Re: Redfern Station Upgrade - New Southern Concourse **Application Number SSI-10041**

REDWatch wishes to object to this proposal in its current form.

Figure 4-1 Option 1

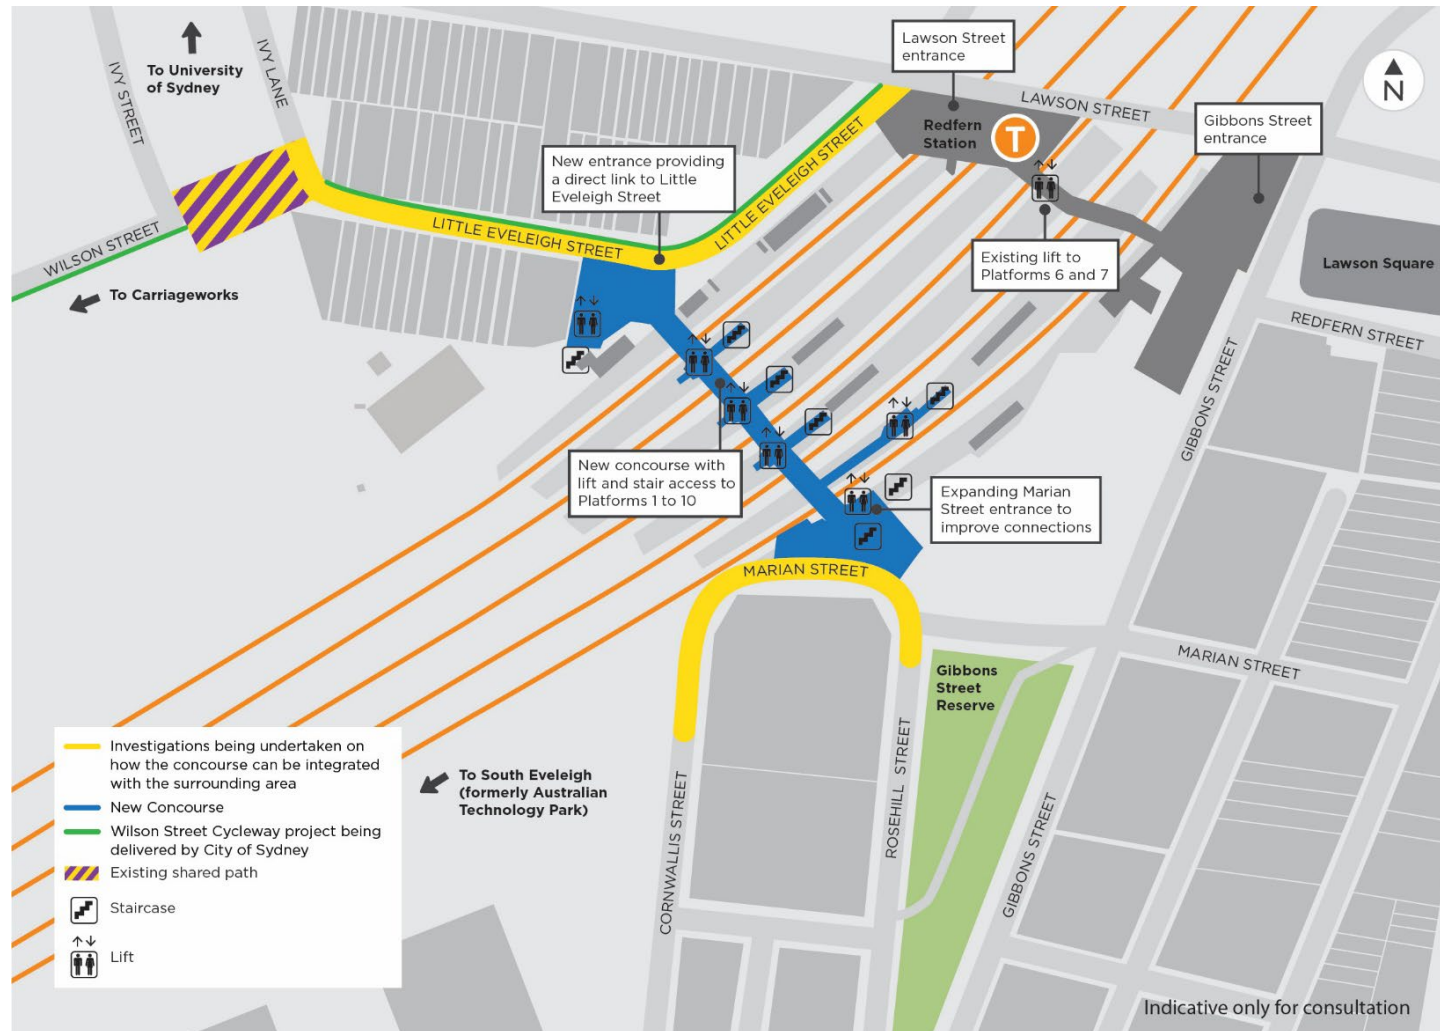
- 1) TfNSW Option 1: Little Eveleigh Street Connection – The key issues with this model are discharge into Little Eveleigh and Marian Streets which create the problems earlier mentioned.

Figure 4-2 Option 2

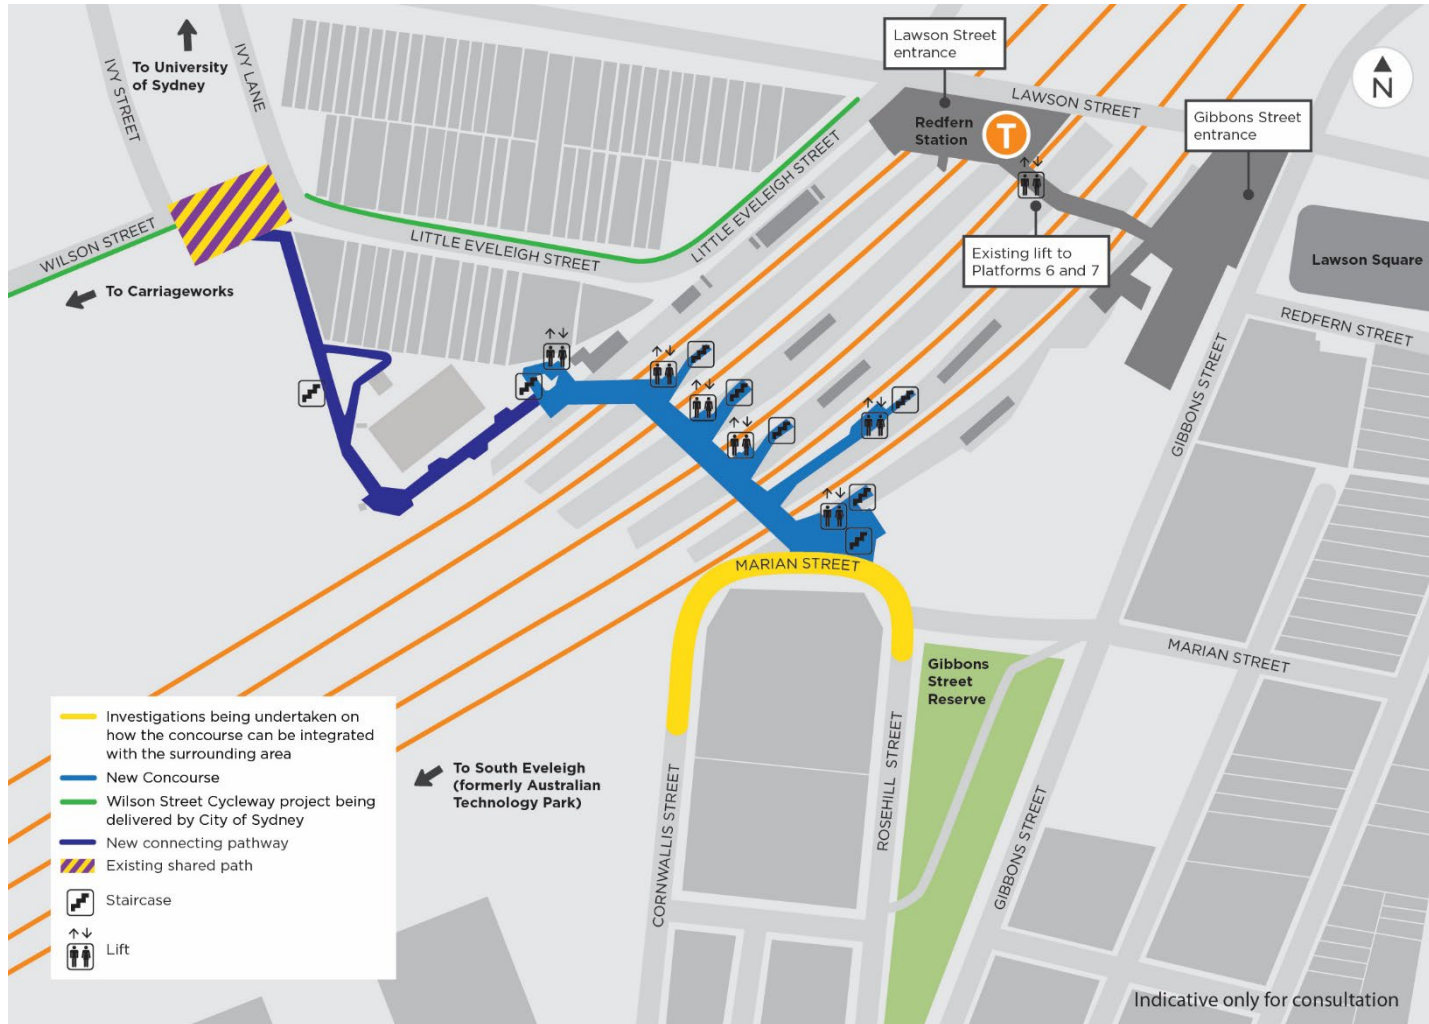
- 2) TfNSW Option 2: Ground Level Pathway (Wilson St Connection) – This option avoids Little Eveleigh Street but it is not a direct route, goes down and up, and does not address problems at Marian Street.

Figure 4-3 Option 3

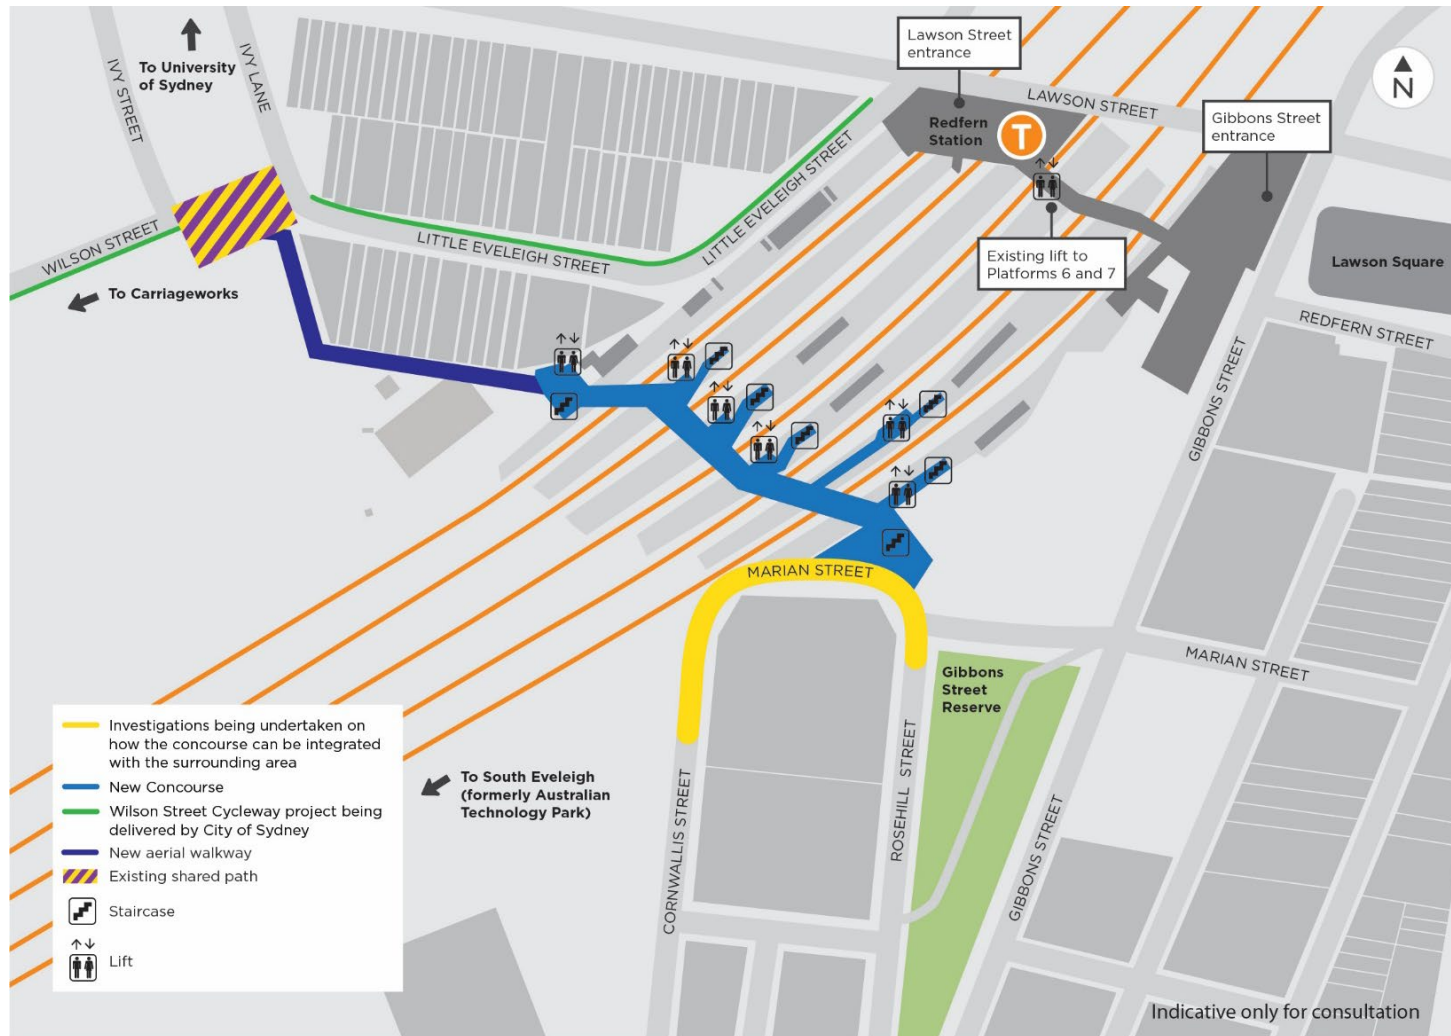
- 3) TfNSW Option 3: Aerial Walkway (Wilson St Connection) - This option avoids Little Eveleigh Street, but to make it more direct, goes over the top of the heritage building and places a privacy barrier at the rear of South side Little Eveleigh St residences. It does not address problems at Marian Street.

Figure 4-4 Option 4

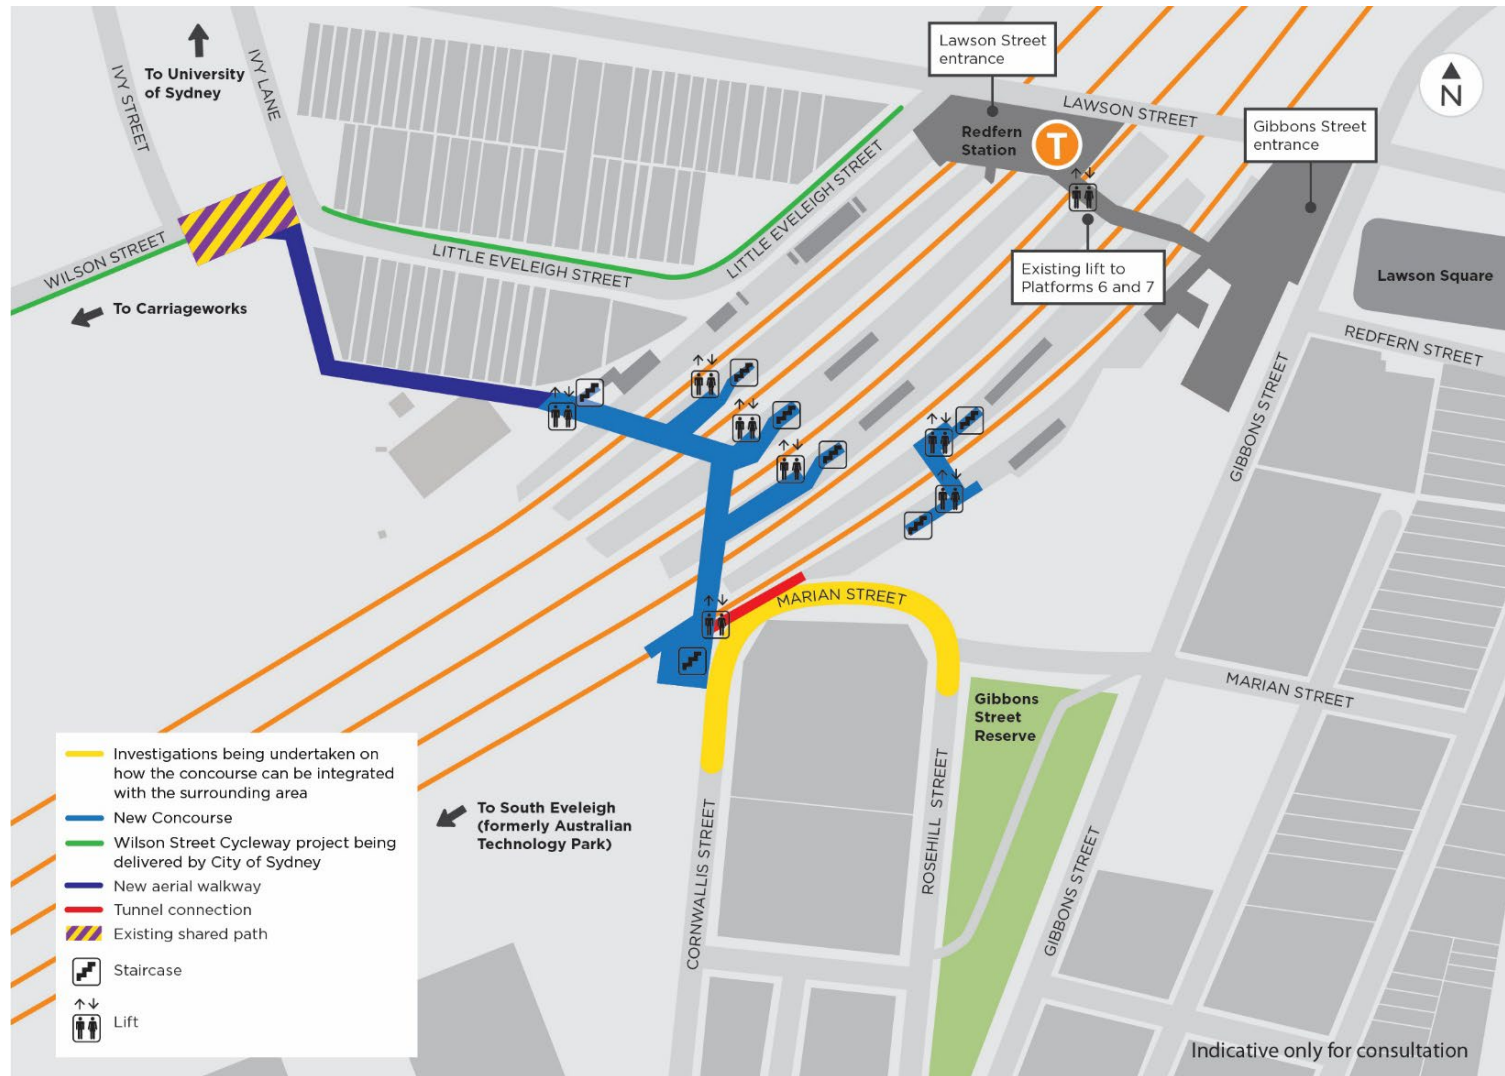
- 4) TfNSW Option 4: South Eveleigh to Wilson St Connection – this is the only option that addresses Marian Street issues, but even TfNSW argues this is not viable as it does not provide a single concourse.

Figure 4-5 'Option 5' received as feedback during community consultation for the Project

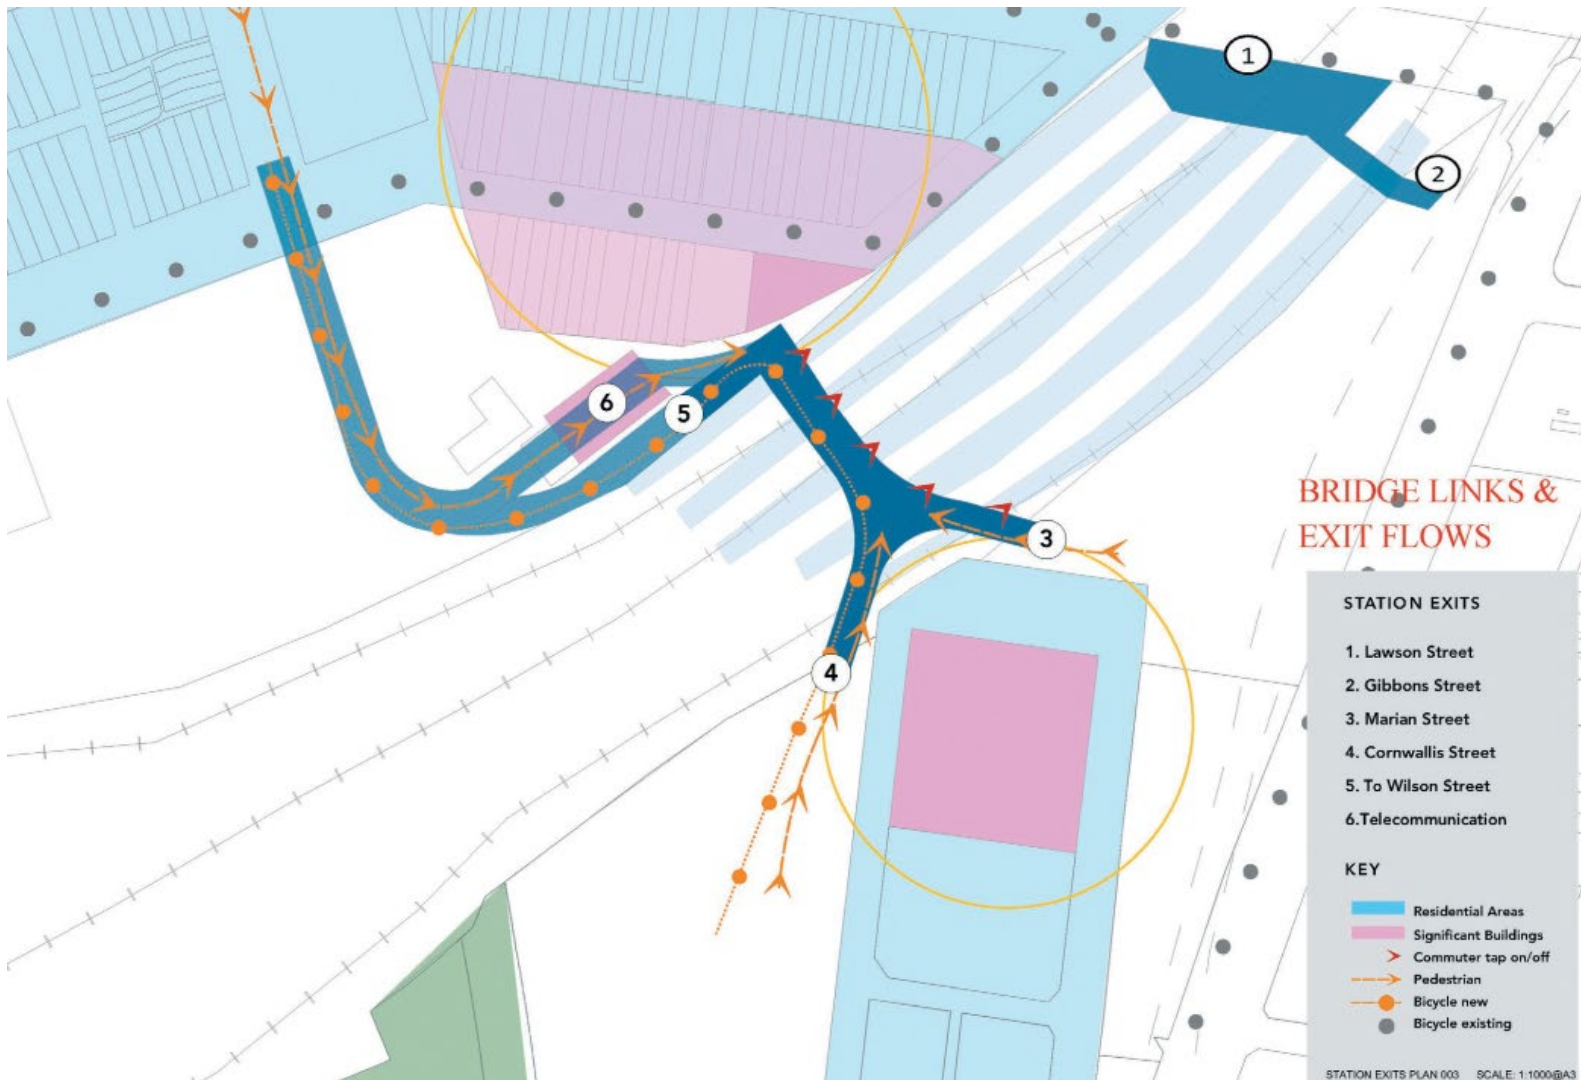
Journey - (Cracknell & Lonergan Architects v2) – This option was a response to a Reconnect Redfern meeting asking why can't we go through the heritage building and adaptively reuse it. This was seen as an acceptable alternative to a flyover option that was higher than people's back fences. While Cracknell & Lonergan drew this as going through the building lengthways this was not necessarily the intention of the meeting.

It was felt by REDWatch and Reconnect Redfern that this proposal was close enough for a concept drawing for presentation as the community option 5. It shows how to combine both a pedestrian and bicycle cross-railway bridge with a paid concourse. It is not an ideal outcome, but it fits with TfNSW's stated aim of having only one bridge. It meets the concerns raised by REDWatch and Reconnect Redfern.

Figure 4-6 Option 6/'H-design' received as feedback during community consultation for the Project

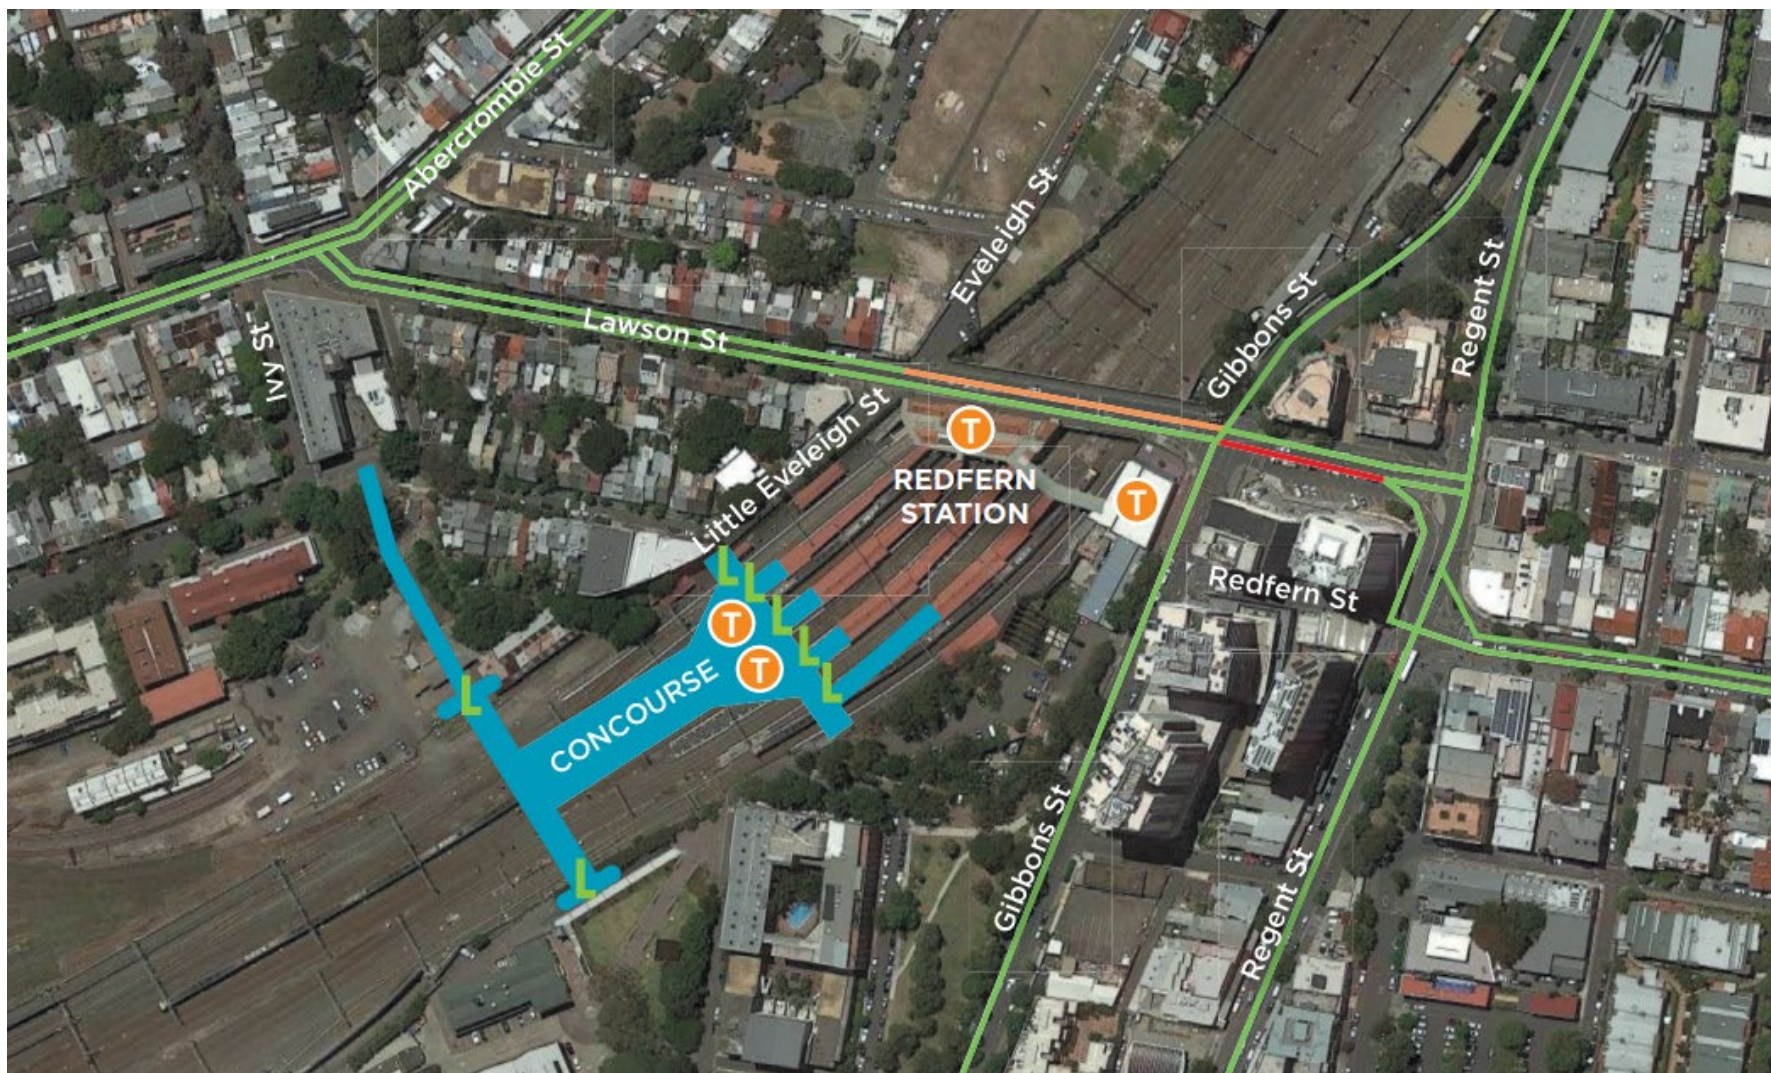
Journey – “H” Design – This was an early option from The Watertower. It was in line with the RWA proposal for a bridge between North and South Eveleigh that linked to a southern concourse. It puts the concourse where it needs to be for the platform constraints and the non-paid North South connection where it needs to be and links them. Transport has argued that this is three bridges and it is only building one bridge as part of an access upgrade. There is a lot of support for this option.

Figure 5-3 Indicative cross section – Little Eveleigh Street and Marian Street shared zones

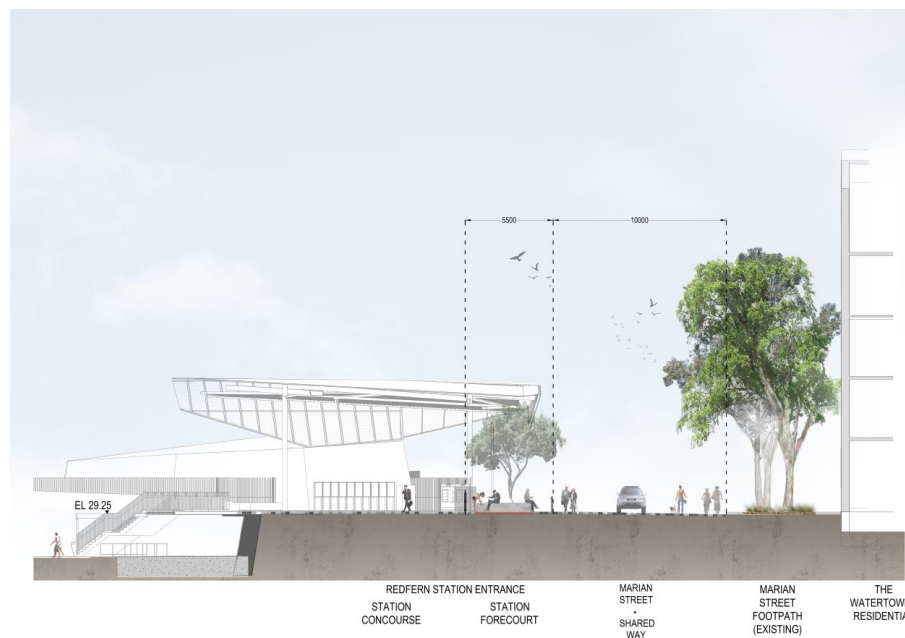
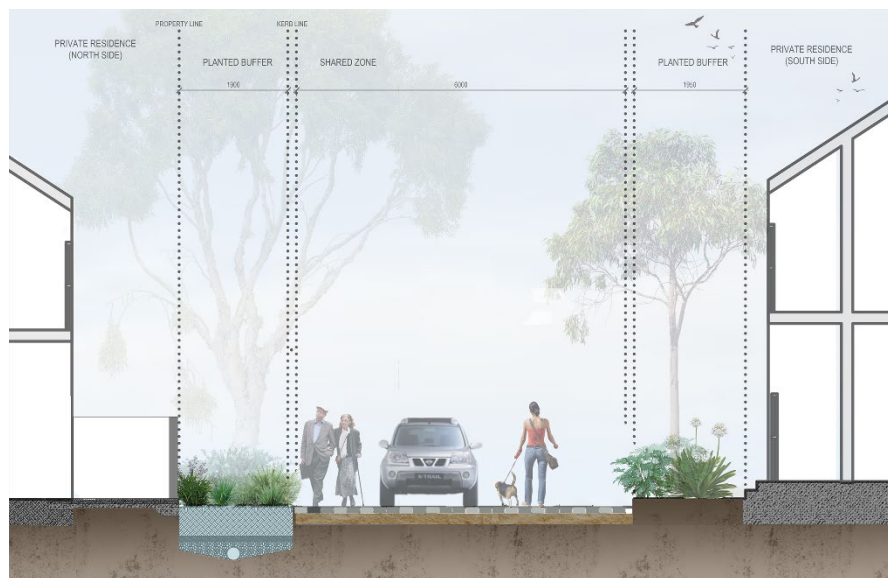
The proposal as exhibited does not deal with the pedestrian issues along Little Eveleigh Street or in Marian Street. The design of how these shared areas will work has been left for a later design consultation to try to address the pedestrian, bike, motor vehicle and noise issues that concern residents in both the access streets. As a result, the key impact on local residents has not been adequately addressed by the proposal and it should be required to do this assessment and re-exhibit.
